October 17th, 2012

**RE: 165 Presumpscot Street: Paving and associated improvements
Level II Site Plan Review
Application ID Number: 2012-605**

TO: Jean Fraser, Planner
FROM: David Senus, P.E. & Ashley Auger, E.I.T.
DATE: October 12, 2012
RE: 165 Presumpscot Street, Final Level II Site Plan Application

DRAWING NO. **C-10**

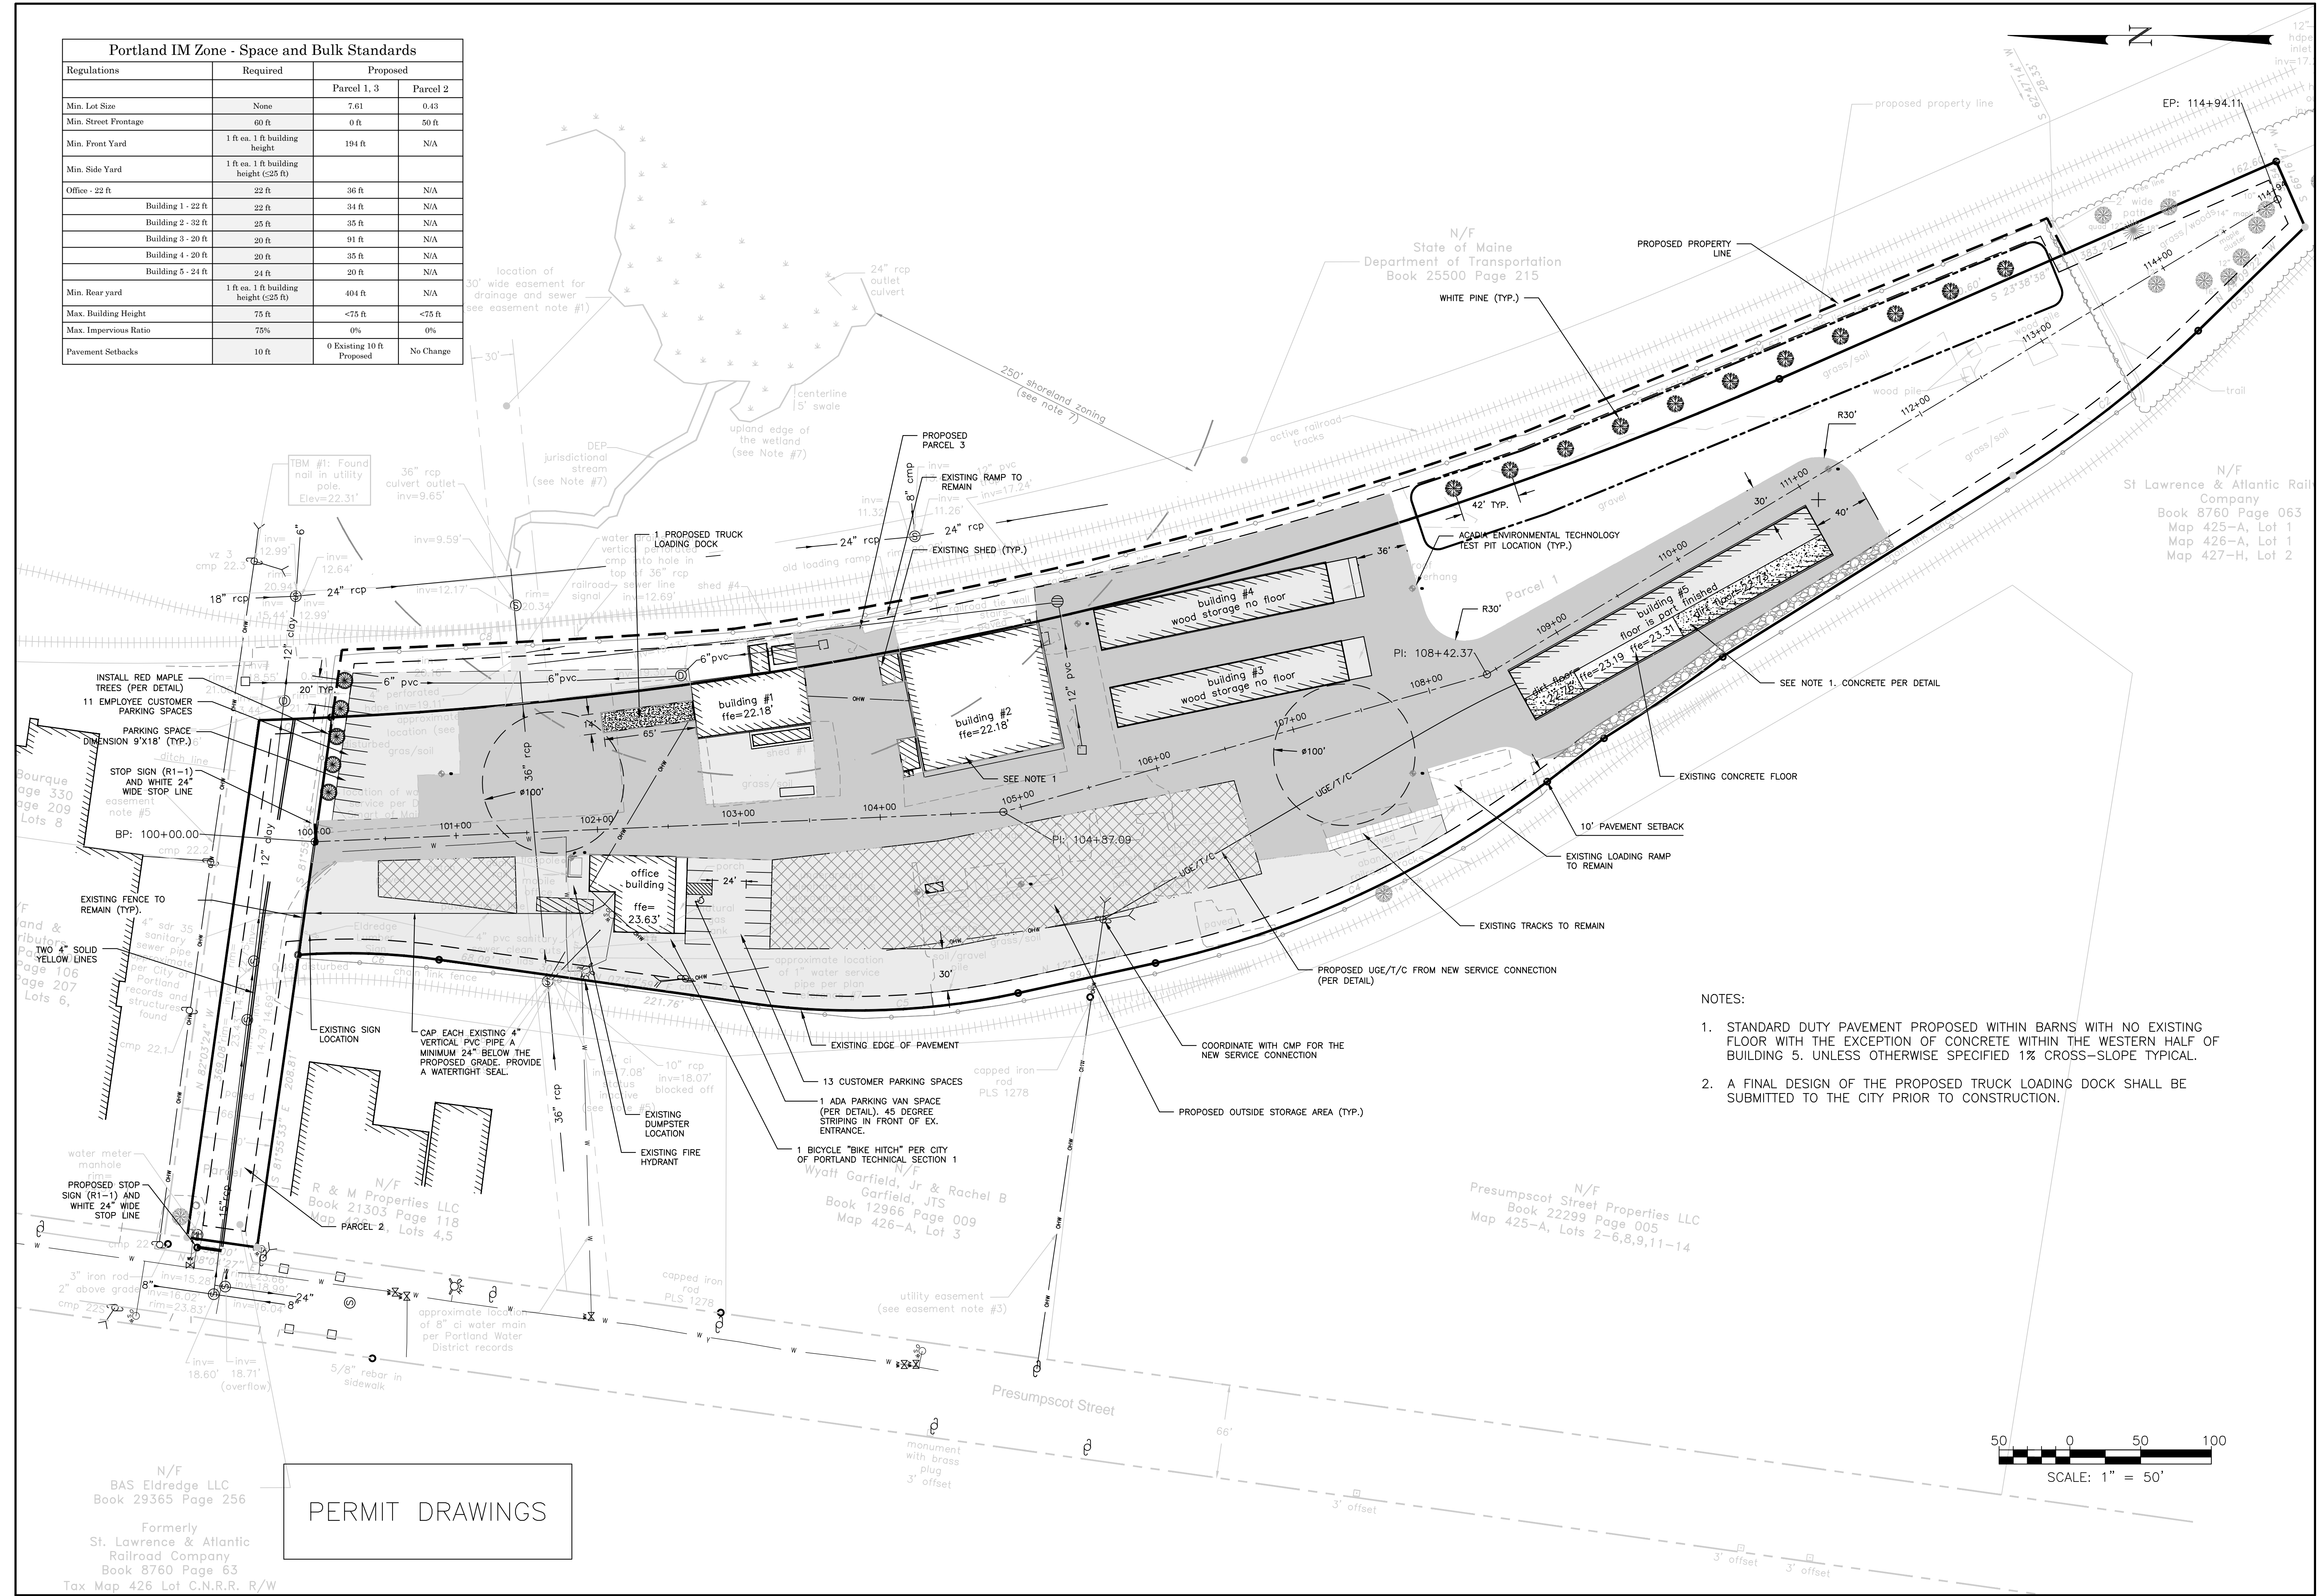
Bicycle Parking: We note your request for a waiver of the bicycle parking requirements in the Site Plan Ordinance. A waiver is not supported as we consider that employees may wish to commute by bicycle, but we would require only 2 bicycle parking spaces (one "hitch") rather than the 4 spaces which would be the Ordinance requirement. We support a waiver for the scooter and motorcycle parking.

Zoning: Thank you for the parking analysis and please revise the plans to show an additional two parking spaces to meet the zoning requirements. I attach the Zoning comments for your information since they clarify several points.

- The Ordinance clarifies that the plans need to show proposed site landscaping and screening. The southern part of the site abuts a residential zone (R-5) on the east and therefore the Ordinance *Site Landscaping* requirements for industrial and commercial zones would apply. In this case the proposed berm would provide some screening, but it would need to be landscaped. We suggest red or white pine tree-planting along this south-eastern edge.

- The Ordinance requirements for parking lot landscaping (see *Landscaping and Landscape Preservation: Parking Lot Landscaping*) applies to all parking on the site, not just to additional parking. Please add tree planting to the site plan along the front of the identified parking nearest to the access drive and railway; red maples are suggested.

DRAWING NO. **C-20**

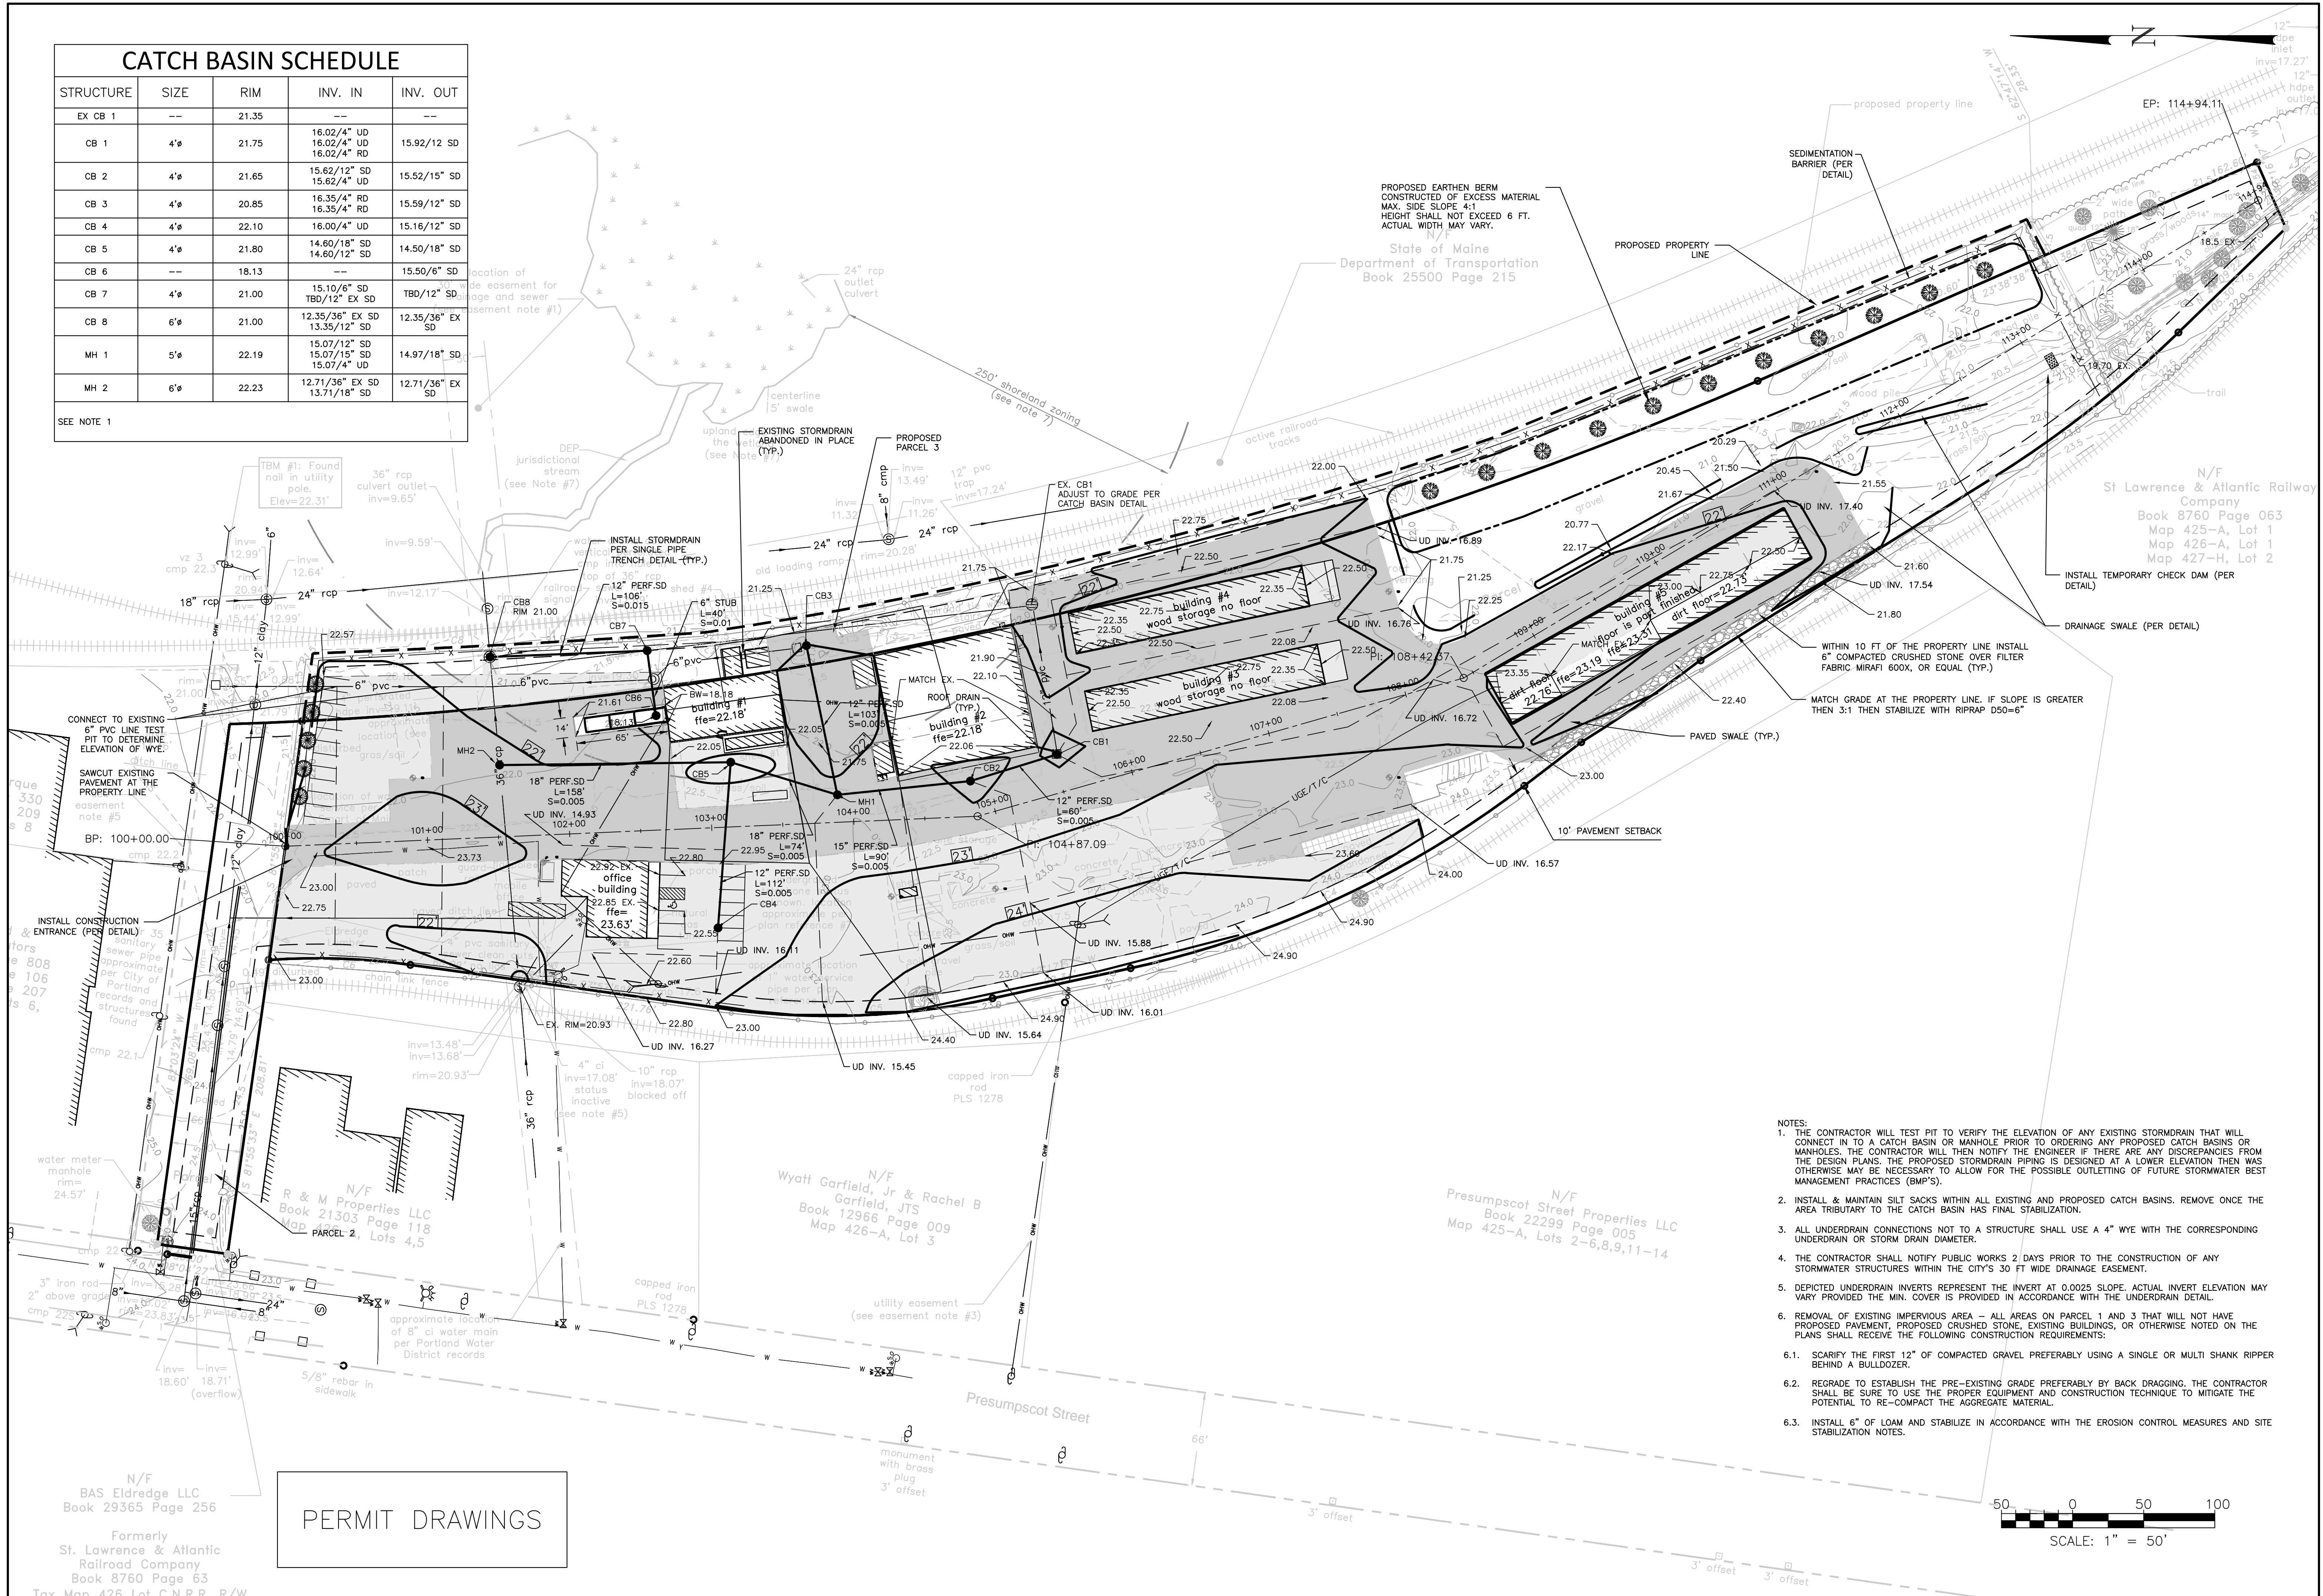
- 4) Sheet C-20 depicts a compacted gravel swale along the west edge of the site, adjacent to and parallel with the west wall of building #5. Concentrating flow over compacted gravel will result in erosion. We understand that the applicant is attempting to maintain a 10' pavement setback from the property line in this area, but we request the applicant propose an alternate surface (crushed stone) or alternate drainage concept in this area to avoid erosion.

- 2) The applicant is proposing two Inserta-T connections for new 12 and 18-inch storm drain pipes into an existing City-owned 36-inch RCP storm drain that crosses the site within a 30' wide easement. Per discussions with DPS, the applicant should utilize drain manhole(s) for these connections. A single drain manhole that allows for both connections would be acceptable; however, the applicant will need to verify that the pipe elevations and the configurations of the pipe penetrations can be accommodated by a single structure.
